From: [Rich Elliott](#)
To: [Kelly Bacon \(CD\)](#)
Subject: RE: [Ext] Notice of Application CU-21-00002 Sweetwater Ranch
Date: Tuesday, March 9, 2021 9:49:48 AM

KVFR input:

Kittitas County CDS is requesting comment on the Conditional Use application CU-21-00002 Sweetwater Ranch.

The proposed project would establish an event center that will hold events including but not limited to weddings, barbeques, graduation parties, full season recreational activities, and other similar styled events ranging in size from 250 to 275 people, on approximately 68.80 acres. All application documents can be found through the links below. I have also attached the SEPA Checklist for recording. Please let me know if you have any issues accessing the materials. Comments are due for this application by 5pm on March 24, 2021. If CDS does not receive comments by this date, we will assume your agency has no interest in the application.

# SITE PLAN

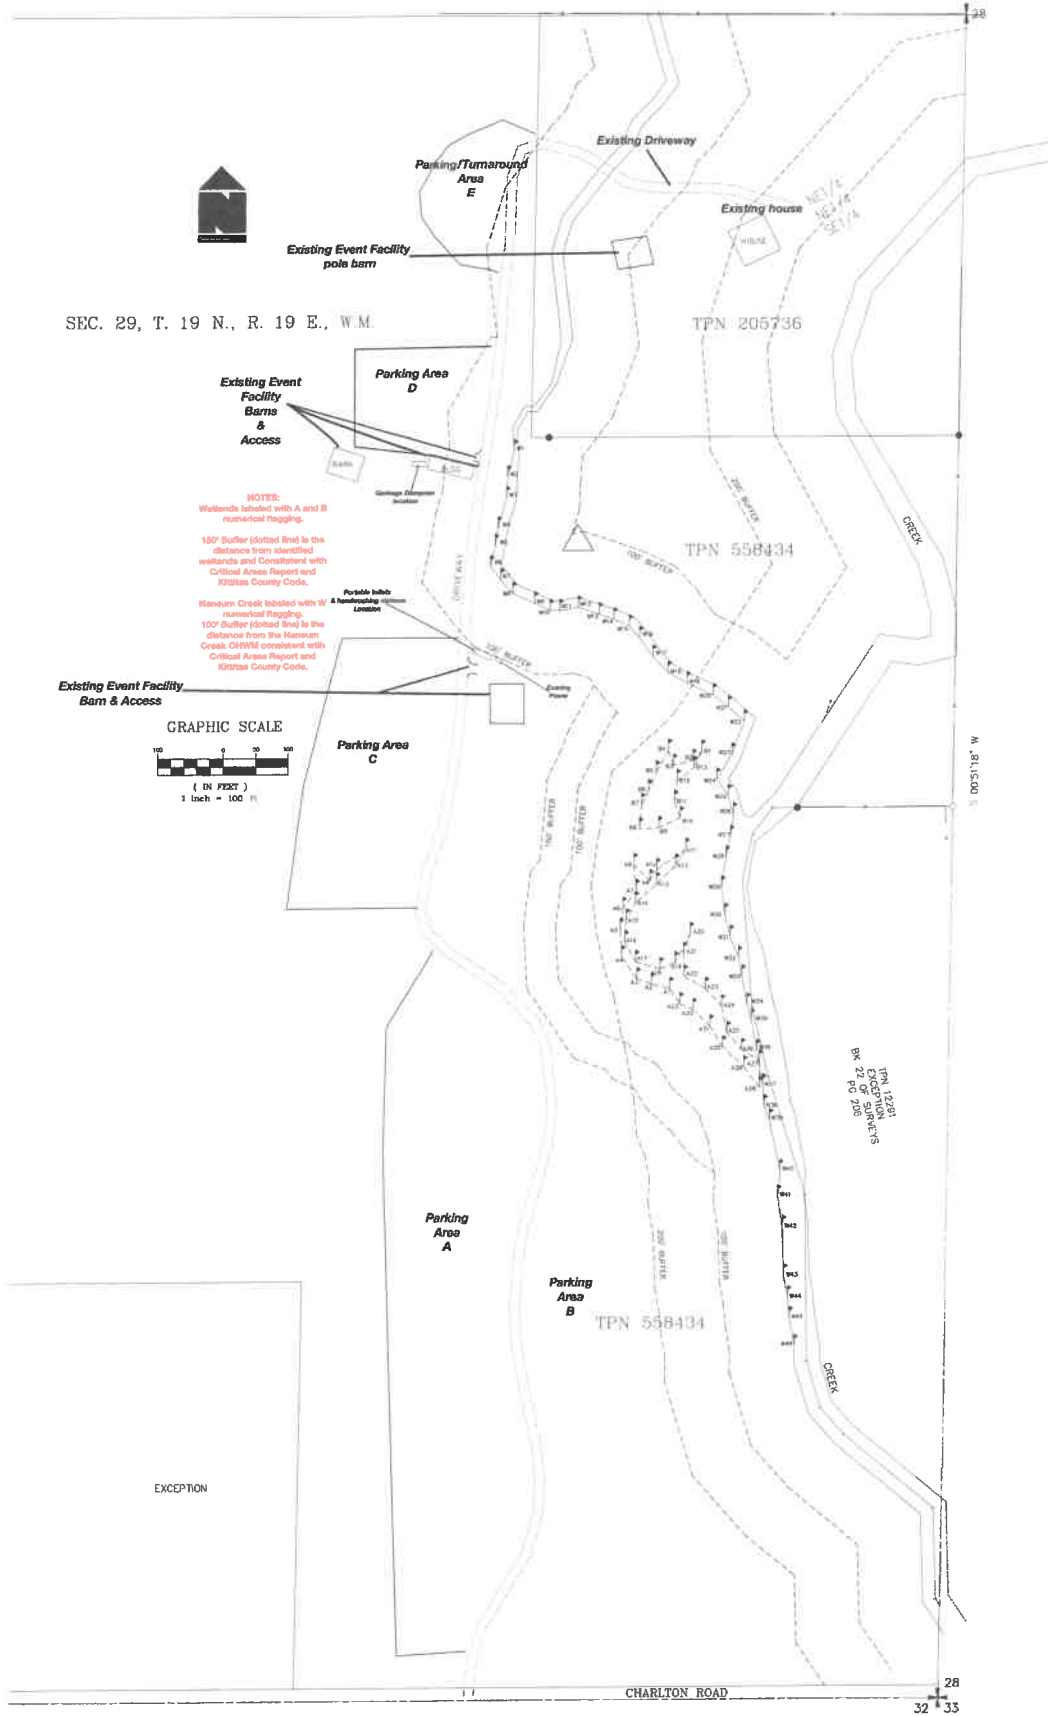
- Fireflow plan – approved by KVFR in terms of access and connections.
- The facility will be subject to a 15+ minute response time.
 - Fire alarm and sprinklers are highly recommended irrespective of code requirements. This will significantly offset on site water storage and fire flow requirements, prevent catastrophic fire loss and reduce life safety concerns.
 - Consider on-site AED for events.
- On-going vegetation management in and around structures, tents and parking areas will be necessary in addition to WUI code compliance.
- 2 separate access/egress roads and Appendix D IFC compliance for all publicly accessible areas. All bridges must be engineered and posted with weight limits – minimum 75,000 lbs.
- Clear addressing and site map at entrance.
- Knox access for buildings and any locked gates.
